Ref: 6/2022/0837/ADV
Date: 27/05/2022

HISTORIC BUILDINGS AND CONSERVATION ADVICE

RE: Cote Brasserie 1-3 Howardsgate Welwyn Garden City AL8 6AL

The application is for the installation of 2 sets of halo illuminated fascia text and 2 externally illuminated projection signs

Proposed Signs

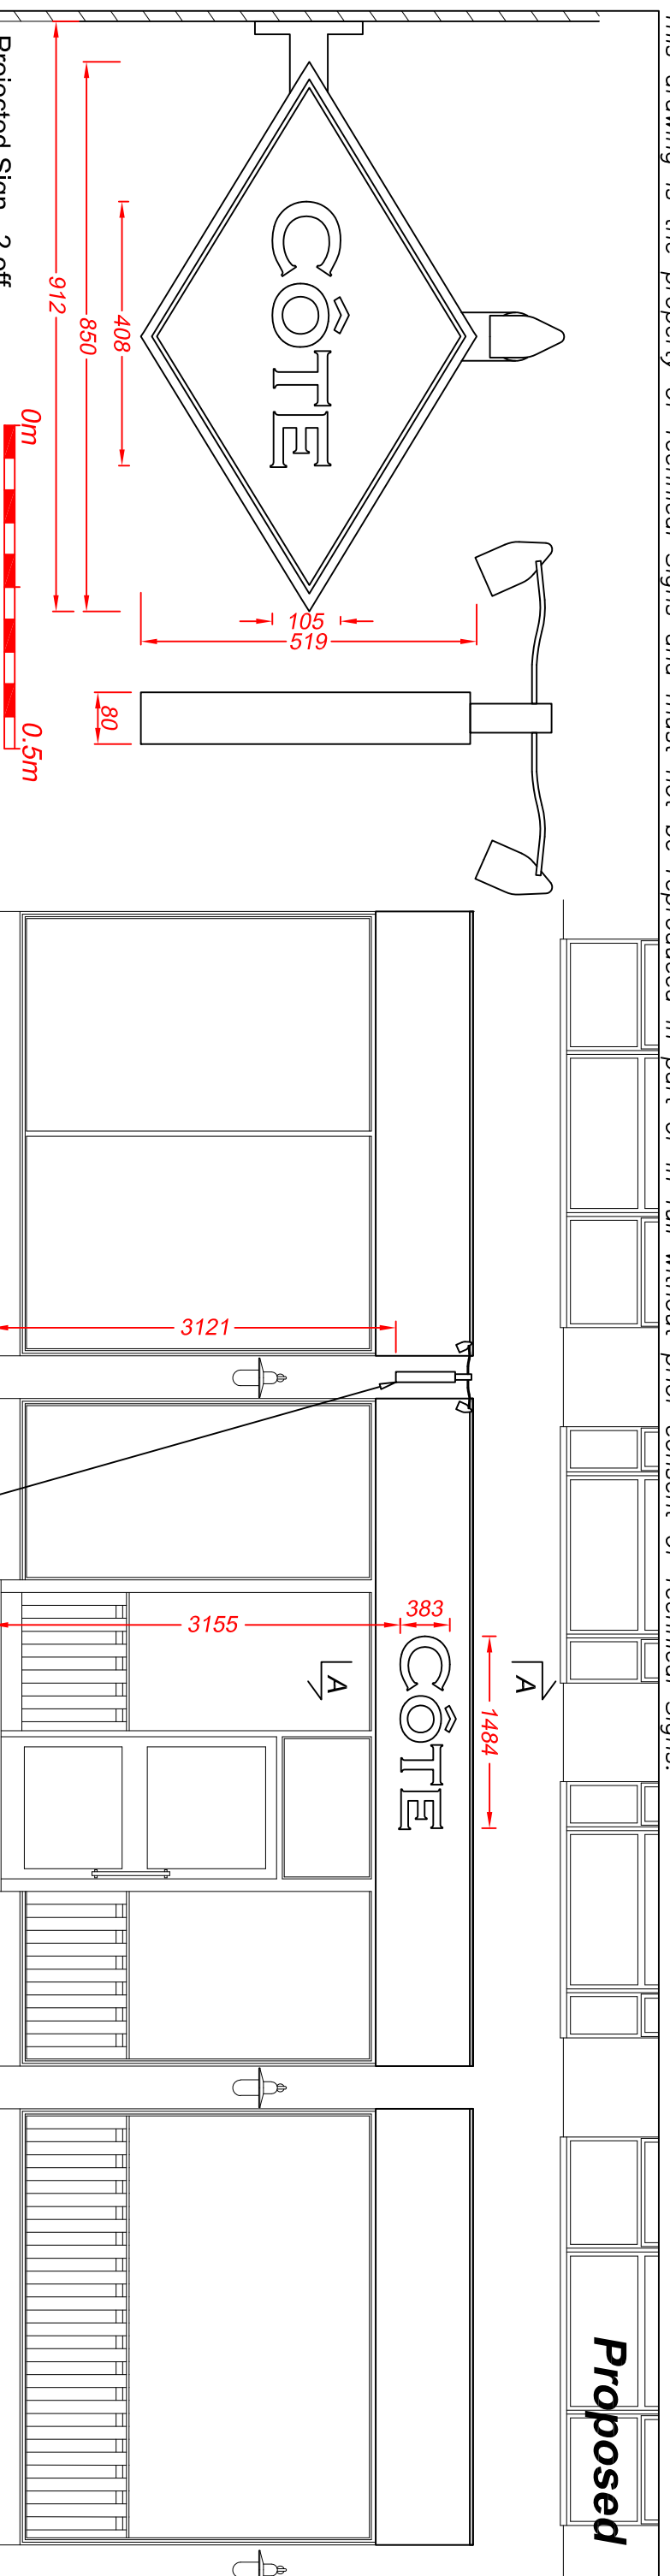
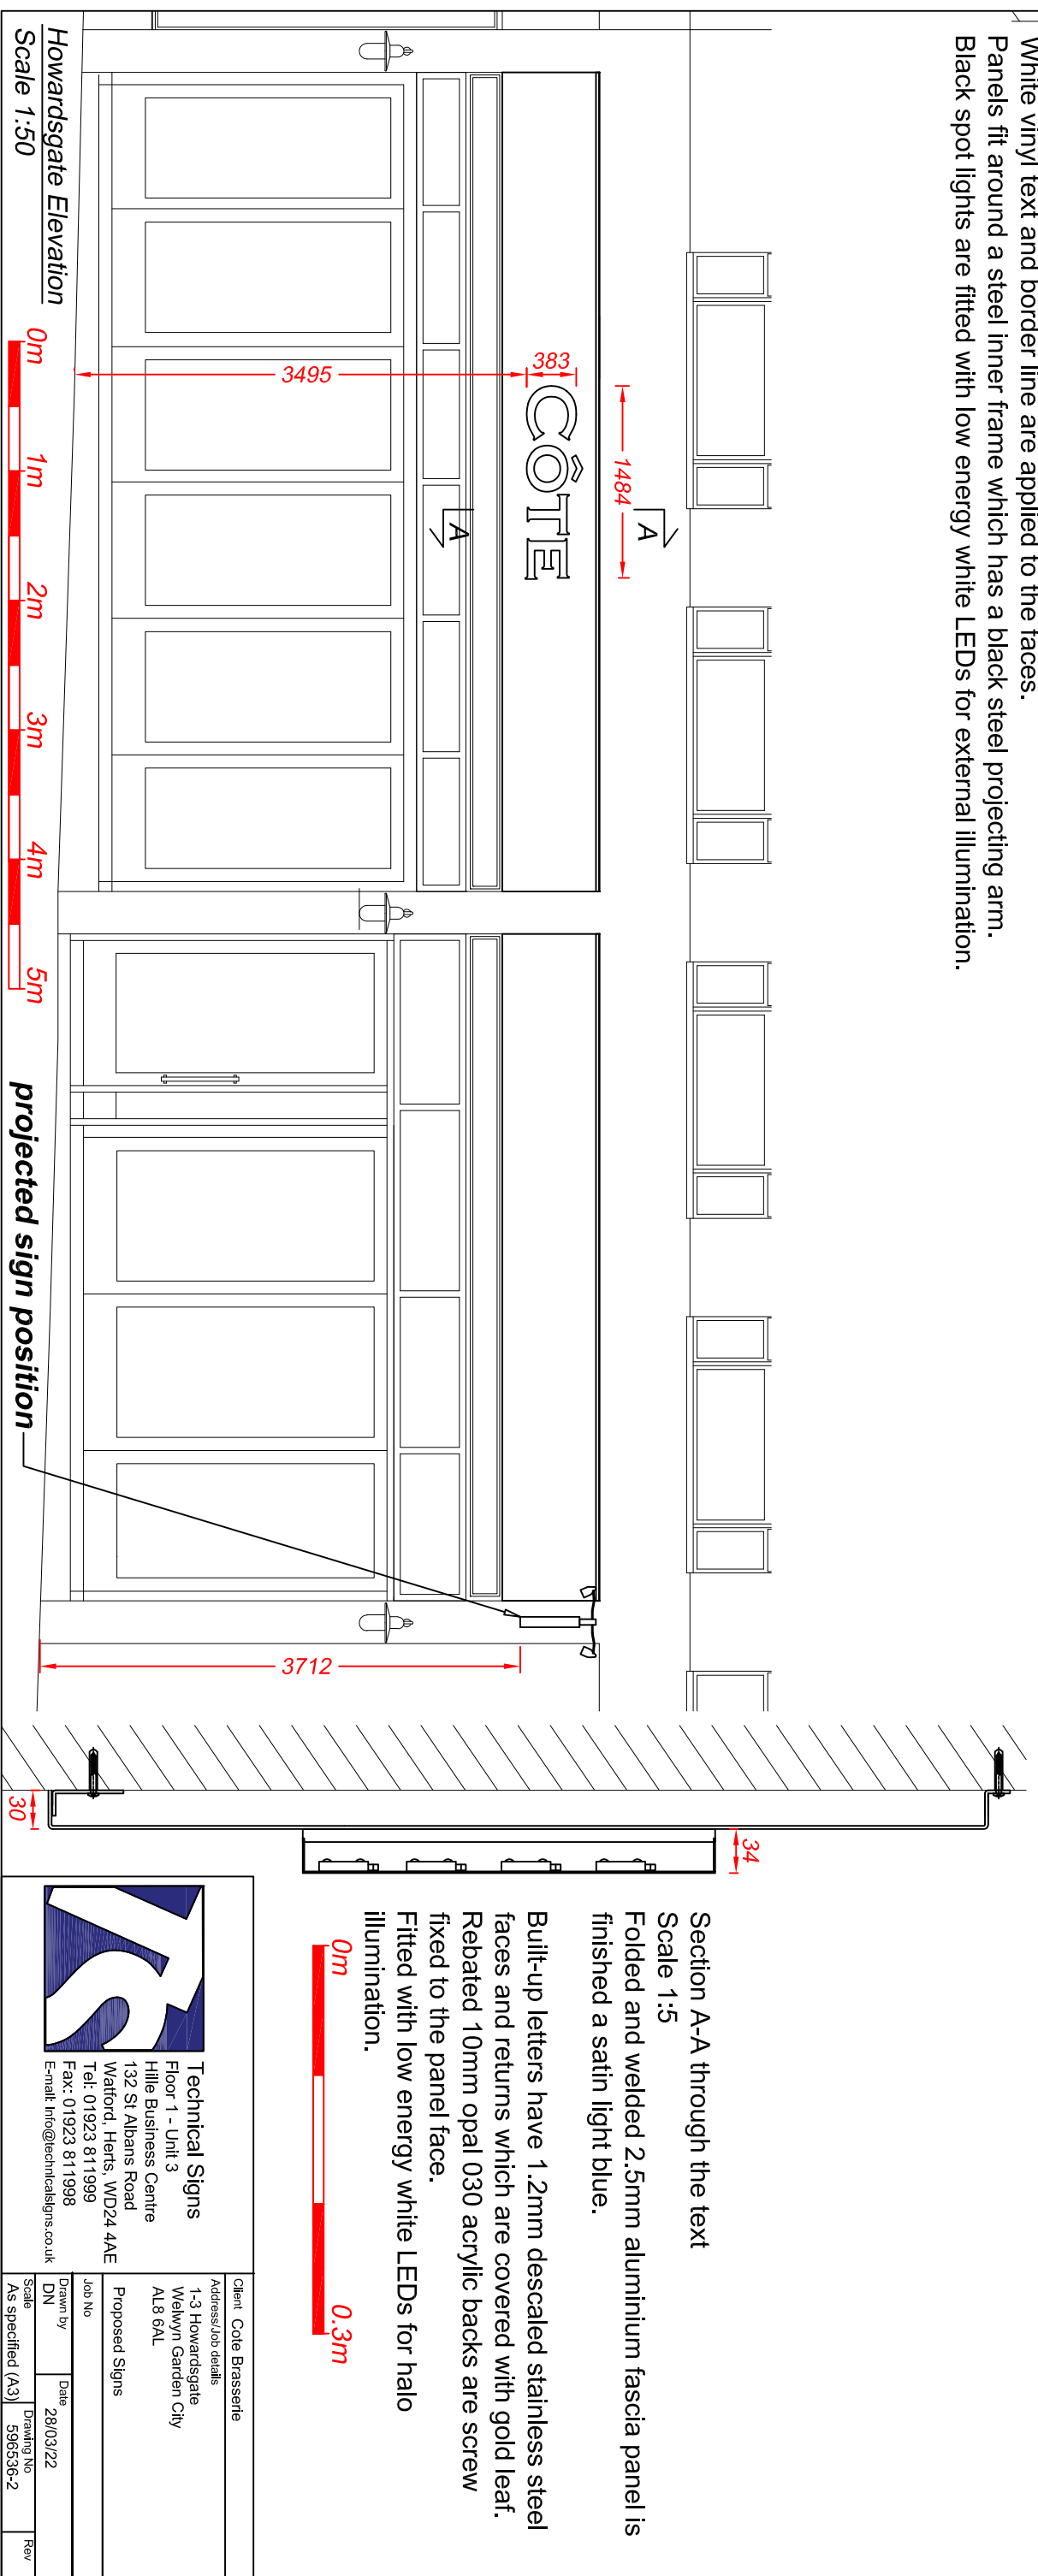
Previous comments stated that there were no objections to the proposed signage. But it was recommended that the internal illumination of the main sign was omitted. An amendment has been submitted that now proposes external lighting for the main sign. This is considered acceptable.
